Engineers Comments Regarding Surface Water Drainage

Application Reference:	M/39/24/DOC	Reviewer Reference:	ADC/PC
Planning Officer:	Kathryn Welch	Date of Review:	28/11/2025
Site Name:	117 Elmer Road Middleton-on-Sea PO22 6LH		
Application Description:	Approval of details reserved by condition imposed under reference M/84/23/PL relating to condition number 7 - surface water drainage scheme.		
Assessment Number:	1 of 2

Surface Water Drainage Report - Sept 2025 MC0539 Naldrett Elmer Road DOC Rev P2

117 ELMER RD Soakaway Section

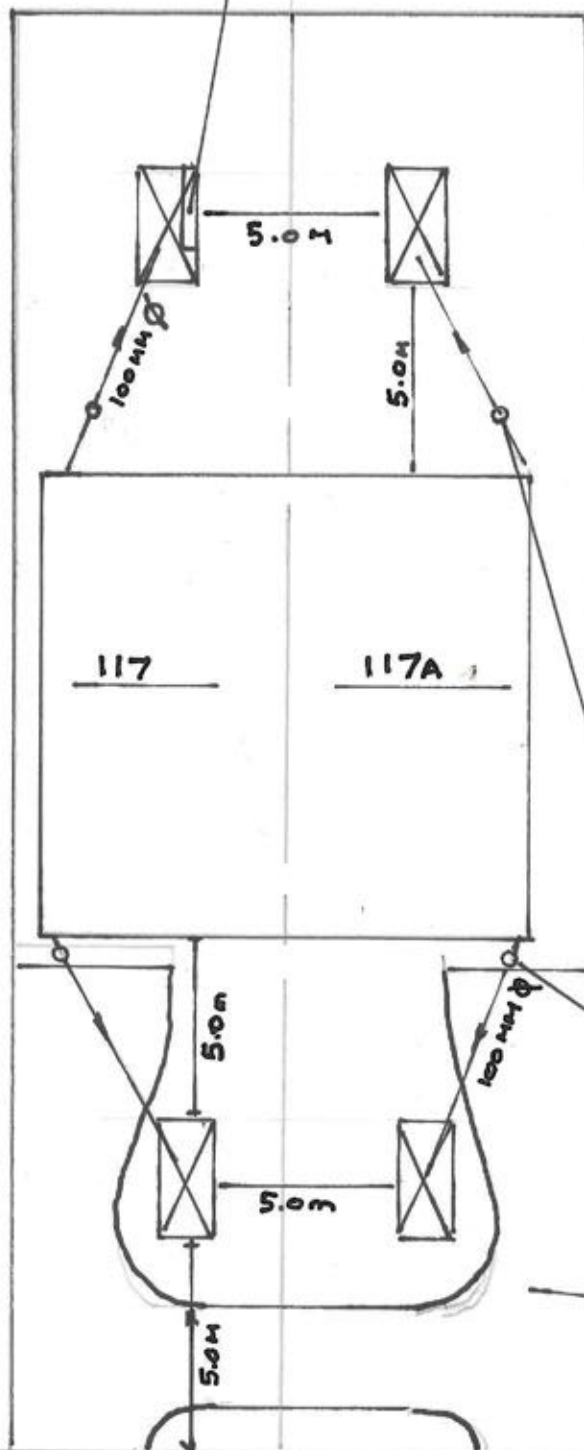
ADC Drainage Comments	ADC Further Comment	ADC Drainage Comments	ADC Drainage Comments	ADC Drainage Comments	ADC Drainage Comments	ADC Drainage Comments
Date:	26/02/2024 [M/5/24/DOC – ADC/SB]	[M/5/24/DOC – ADC/SB]	03/09/2024	21/01/2025	21/05/2025	08/09/2025	28/11/2025
Condition Number: 7							
Comment Number							
	Groundwater monitoring and infiltration testing results are accepted. [The design rate of 8.2×10^{-6} m/s at a design depth of 1.2m].						
1.	Calculations should be based upon FEH rainfall data. (Currently FSR).	Thank you – point closed.					
2.	The proposed soakaways appear to be undersized. The calculations specify a total volume of	Thank you – point closed.

6.28m ² per housing unit. The layout shows a total volume of 2.28m ³ per unit (split between two soakaways, one at the front and one at the rear).

3.	The soakaways at the front of the proposed properties are positioned too close together, ideally these should be 5m apart.	Thank you – described in method but not shown clearly on the layout. Please mark.	Thank you – point closed.

117 ELHERO Sockaway Section
 Sockaway size 3.0m x 1.8m x 0.84m

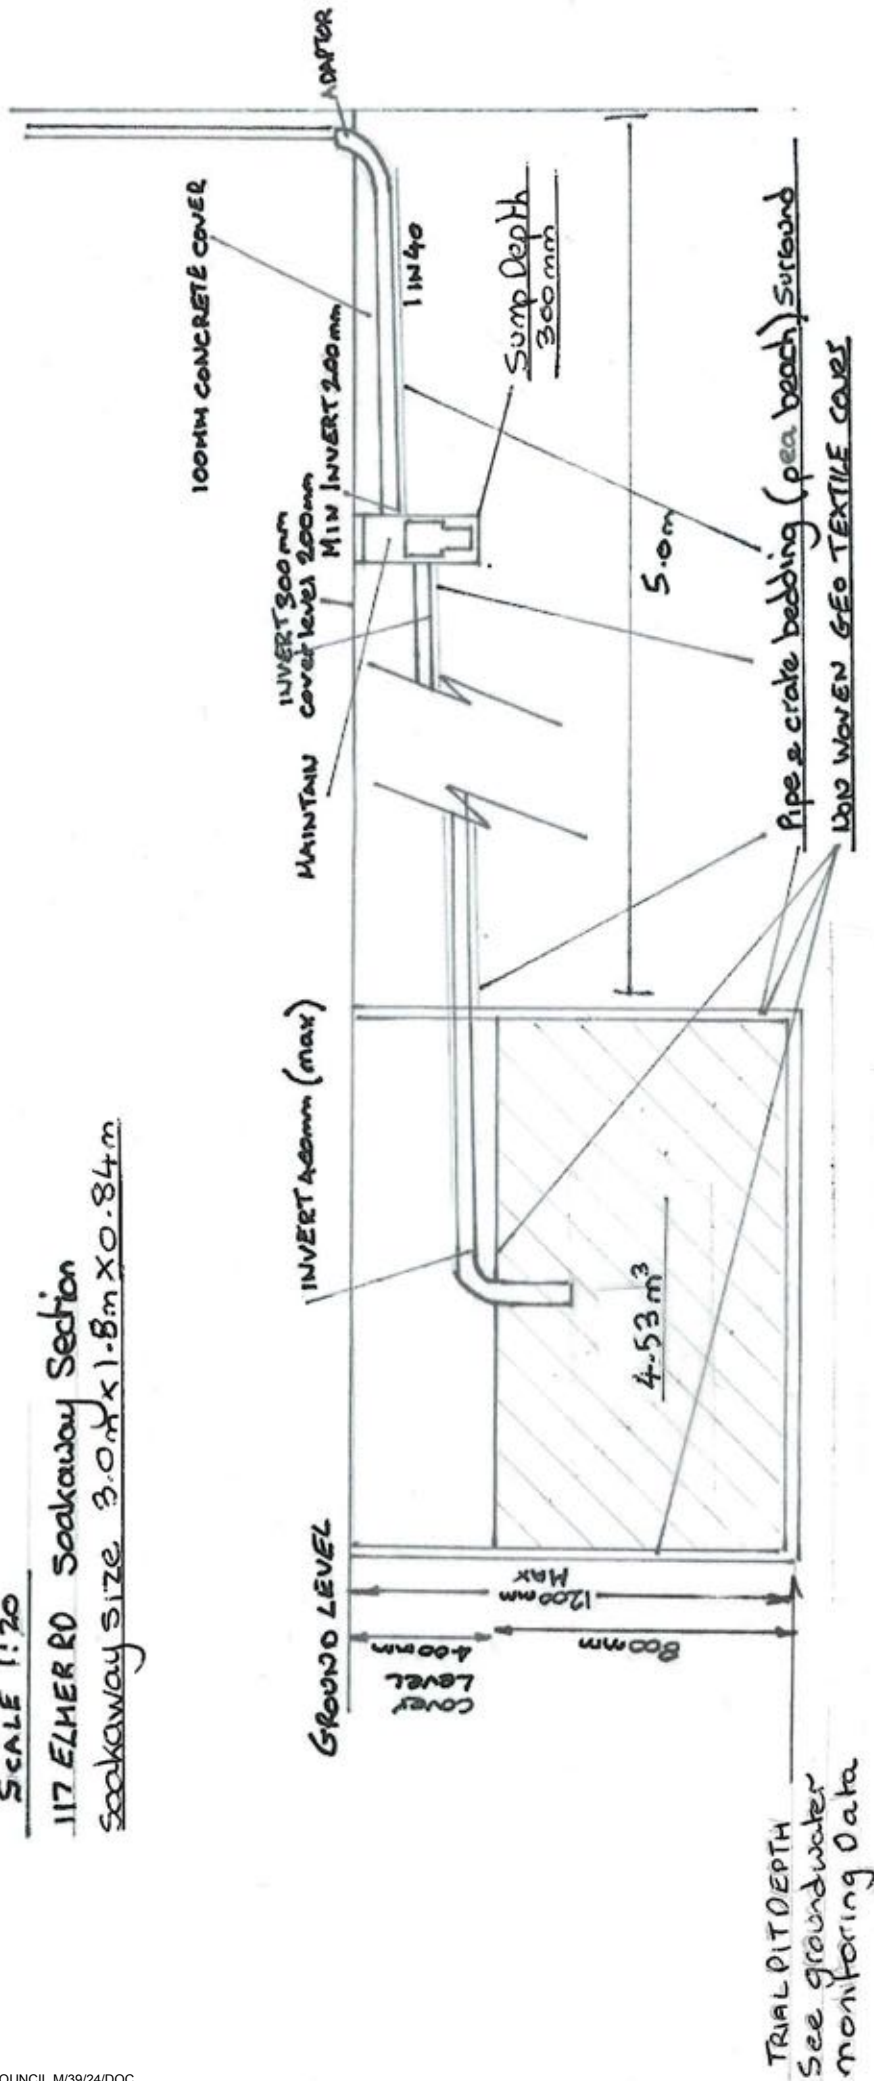
the soakaways is unclear if it relates to the incoming pipe invert level – which we need, or the base of the soakaway. It is unclear what the 300 relates to, mm below ground level?					
6.	Please supply construction detail drawings of soakaways, pipe bed and surround, and catchpits/silt traps.	Not provided – the description of the scheme is noted but technical drawings are required.	Outstanding, please see points 12 and 14 below.	Provided – see comments 14,15, (19), 22, (23), 26-28 below.			
7.	Please ensure that your drainage layout clearly indicates that soakaways are positioned 5m from the proposed properties.	Thank you – point closed.					
8.			Please provide the winter storm profile calculations as they currently only appear show the summer results. Please confirm and show that	Summer CV is 0.75, please correct to 1.	Corrected. Point closed.

drawing assumes level ground. If the ground is not level, then basing the design drawings only on dimensions below ground level can risk an inadequate gradient and siltation of the pipes.				
11.			The cover level of the soakaway is likely to be more than 400mm to achieve a 1 in 40 gradient for the length of pipe proposed. Please adjust the design as necessary.	New design. Point closed.			
12.			Please provide full construction details for the silt traps.	Point closed.			
13.			Please specify the distance of the vertical pipe drop into the soakaway (from	New design. Point closed.

the top of the soakaway to the top of the pipe. [An alternative option is to have the incoming pipe at the side of the soakaway into one of the likely prefabricated inlets. This will aid the designer in achieving the specified gradients without altering the depth of the soakaway.]				
14.			Please specify the manufacturer and model of the crates being used, these need to be checked to ensure that they are capable of carrying the loads at the specified depth, particularly under the driveway.	Notes state 'or similar'. The exact crate must be specified, or the specifications of an alternative. It is capable of withstanding vehicular loading at 1.2m depth.	New construction details. Point closed.		
15.			Please specify that the non-woven geotextile is <u>permeable</u> and make it clear on	Please also label the membrane below the tarmacadam on	New construction details. Point closed.

SURFACE WATER DRAINAGE PLAN
117 ELMER RD
SCALE 1:200

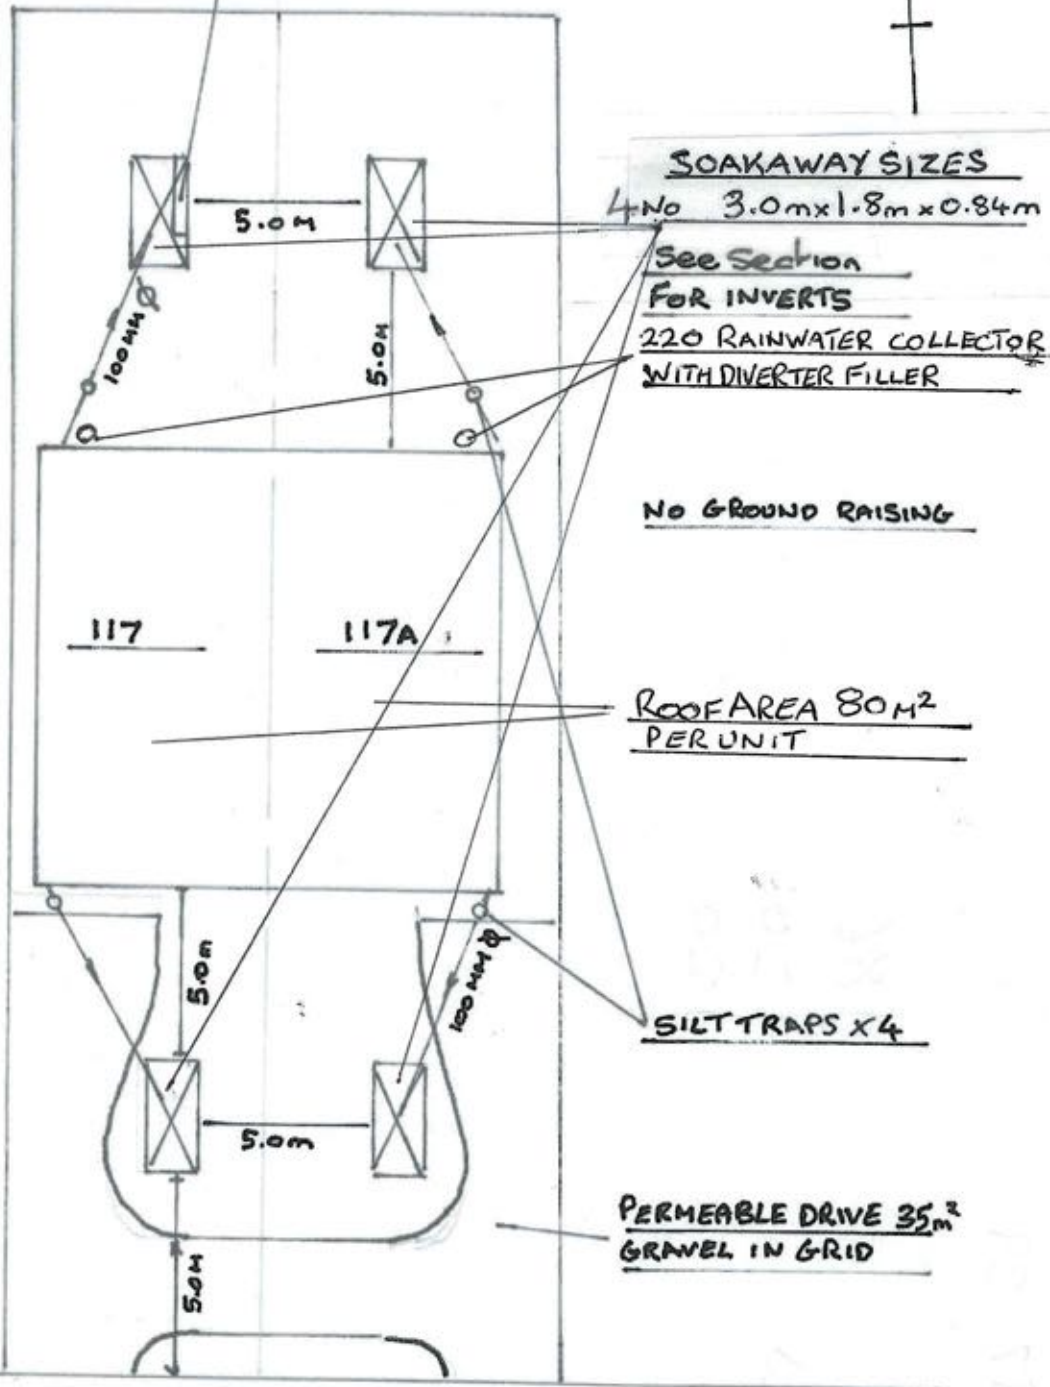
4.	Please provide catchpits/silt traps upstream of all soakaways.	Thank you – point closed.					
5.	The drainage layout requires further detail. Please see guidance note k on the attached drainage checklist for the level of detail required.	Soakaways need to be labelled with base levels and cover levels. Silt traps (which will also be inspection chambers) need to be labelled with cover levels and pipe invert levels. The invert level of '300' given for	Please see points 10 and 11 below regarding 'levels' vs 'depths below ground level' and the risk involved with this descriptor.	Please see comments 14, 17, 19, 20-23 below.

22.				Soakaway base levels appear to not be consistent between the construction details and the layout. It is assumed that the IL labelled directly next to the soakaways relate to the incoming pipe invert levels . Please clarify. It is suggested that the incoming pipe invert level, or the base of the soakaway are labelled with different notation on the layout to avoid confusion.	Design revised. Point closed.		
23.				Suggested: A link could be provided between the permeable paving subbase with a diffuser unit connected to SWM6 so that the two systems are linked to maximise infiltration and storage. This is suggested on the basis of a lack of design infiltration	Link provided through granular material as per construction details. Point closed.

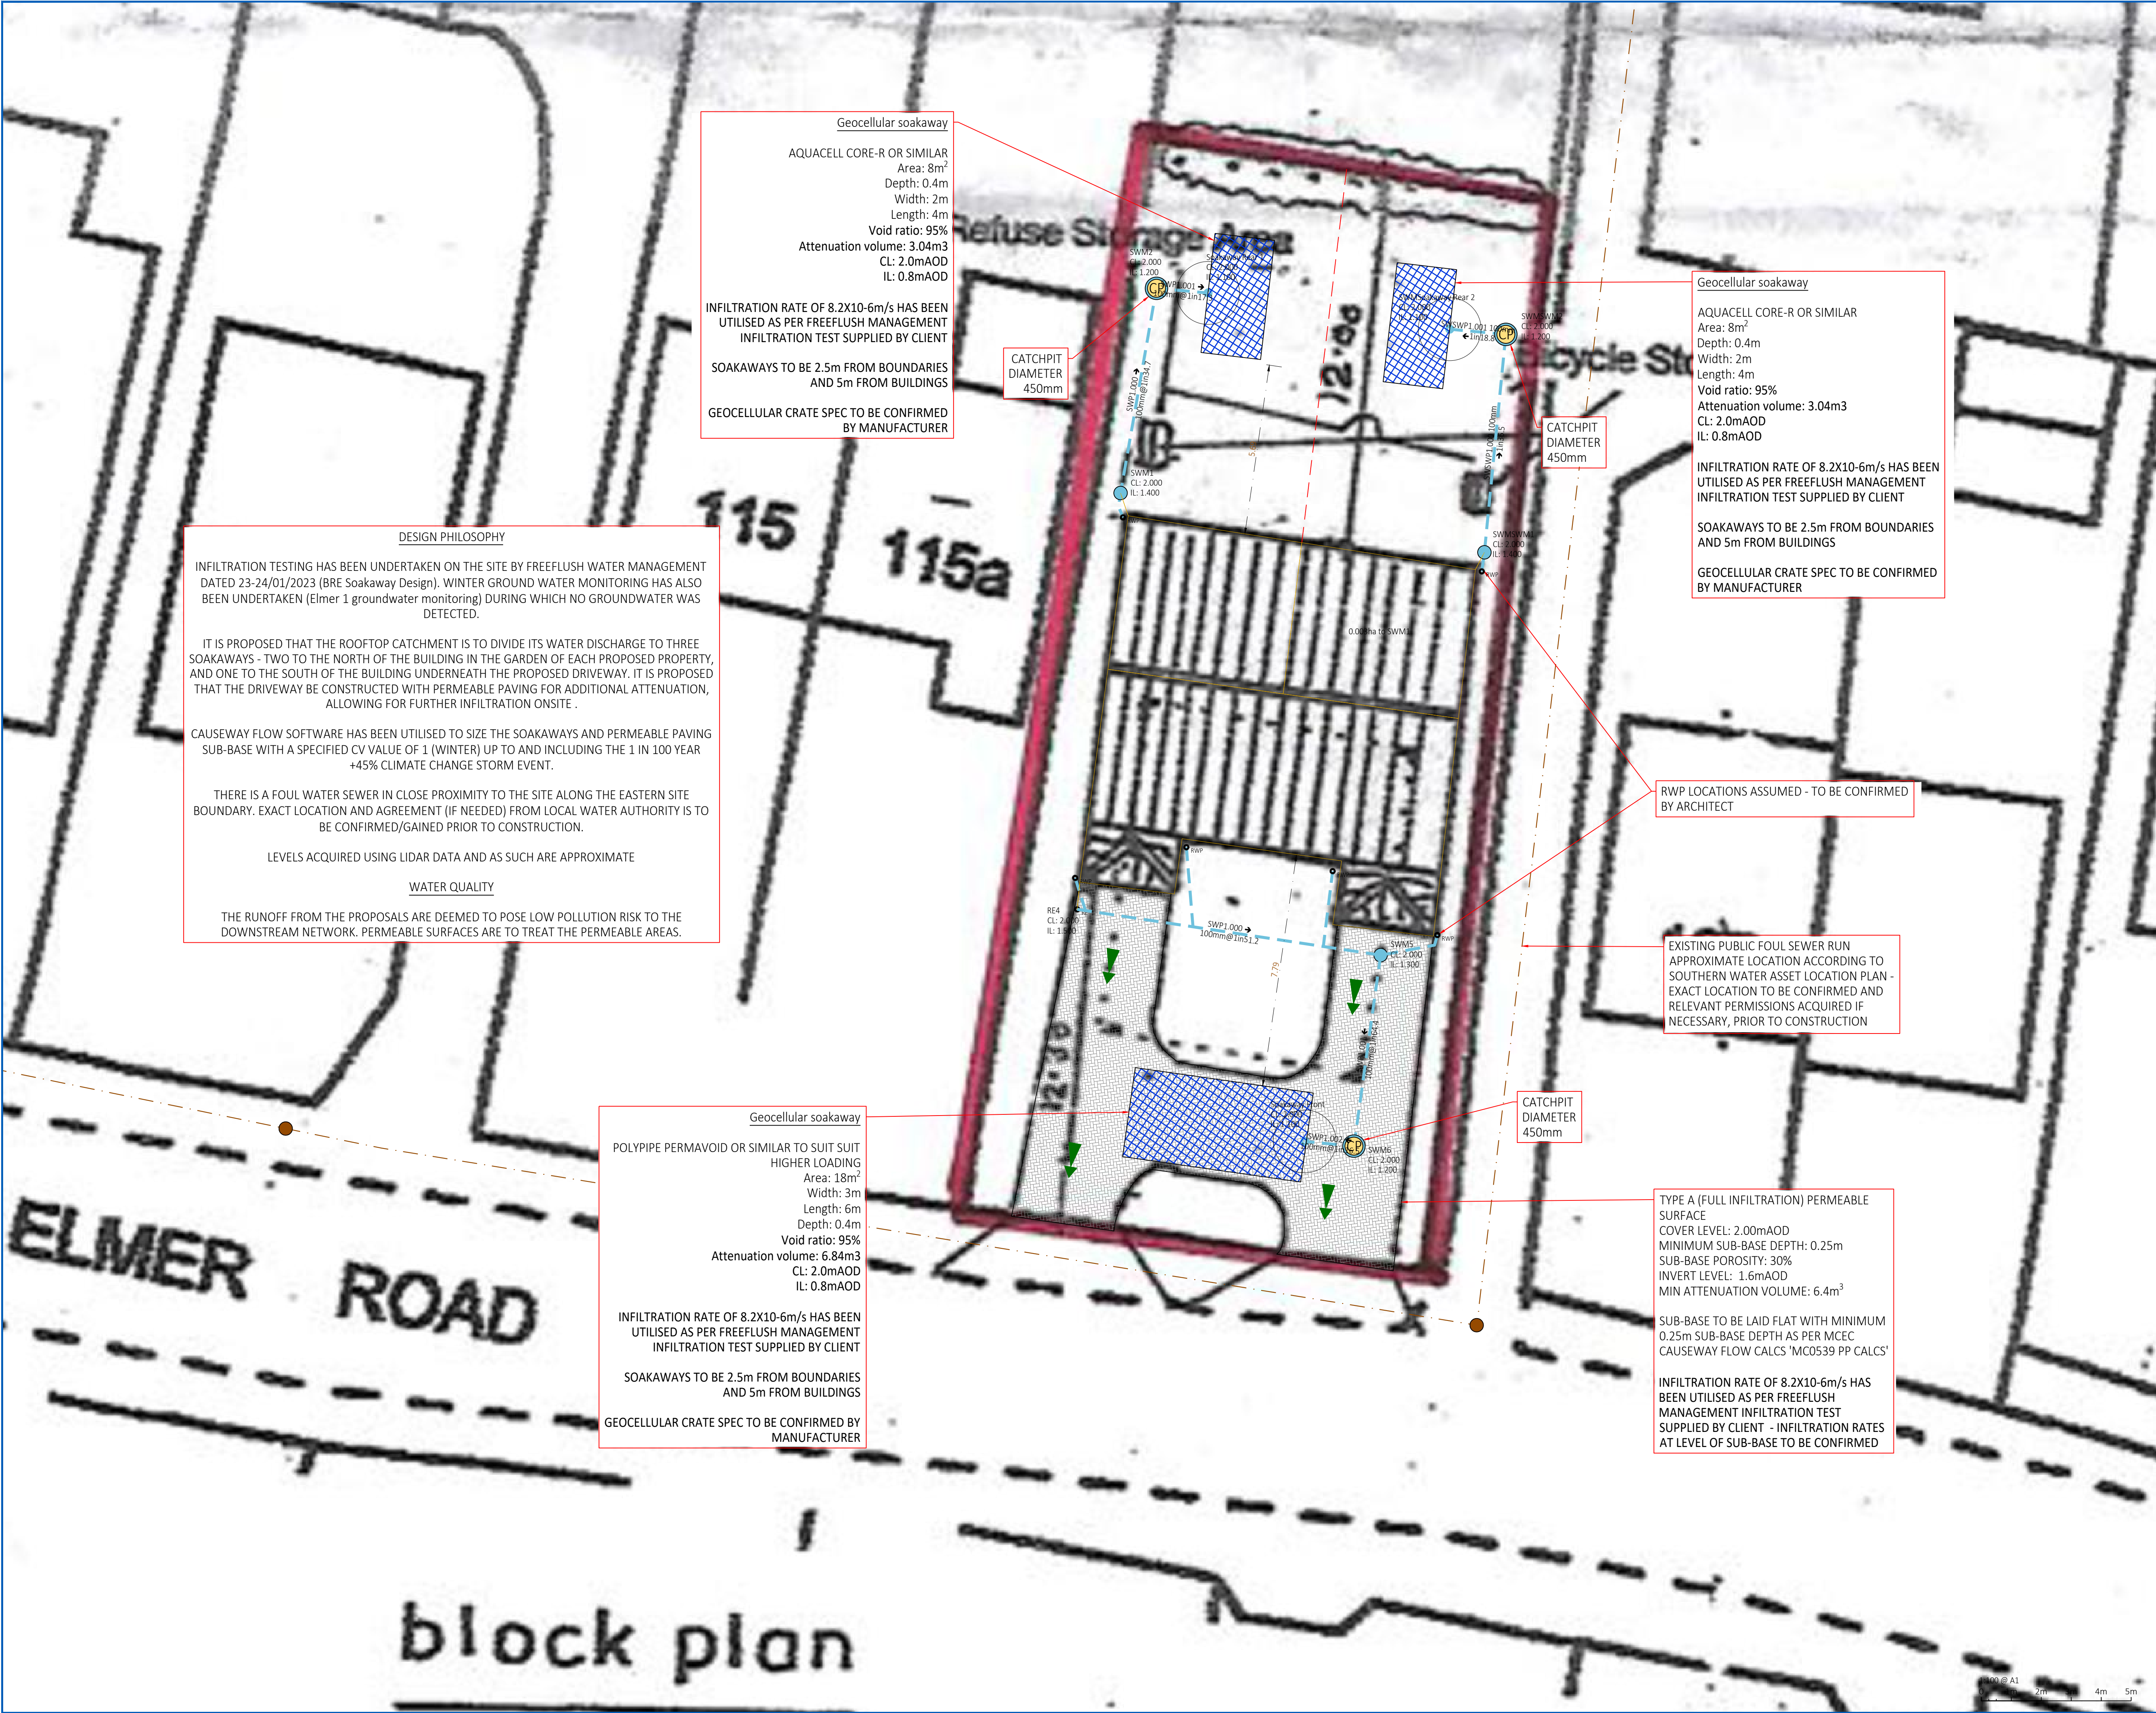
How will management and maintenance be organised between the future homeowners?			
19.				Please provide a plan and details showing how that the new design for the rear soakaways will not be structurally impacted by boundary treatments – particularly in the rear gardens.	Design revised. Point closed.		
20.				Suggested: include dimensions of the soakaways rather than just plan areas.	Design revised. Point closed		
21.				Soakaways must be set at 1.2m below ground level to accord with the infiltration testing (see point 1). Therefore, the soakaways must be set deeper.	Design revised. However, the layout plan shows the soakaway bases set at 0.4m AOD as opposed to 0.8m AOD. The construction details show it correctly. Please adjust accordingly.	Rear soakaway bases have not been adjusted.	Adjusted. Comment closed.

as previously requested.	
31.				Please illustrate exceedance flow routes.	Site is flat so difficult to assess. Point closed.		
32.					Hydraulic calculations for the permeable paving are noted with the 40% additional inflow. The linkage through granular material between the permeable paving and the crate soakaway at the front of the property is also noted. However, since the infiltration rate at the depth of permeable paving is unknown, please provide additional calculations for the front crate soakaway only, ignoring the permeable paving and associated inflow. This is just to sense check that the soakaway can cater for the roof area only by utilising infiltration through its base only and not rely on the permeable paving base.	Point closed.	
33.					Pipe bedding details – specify depths of	Point closed.
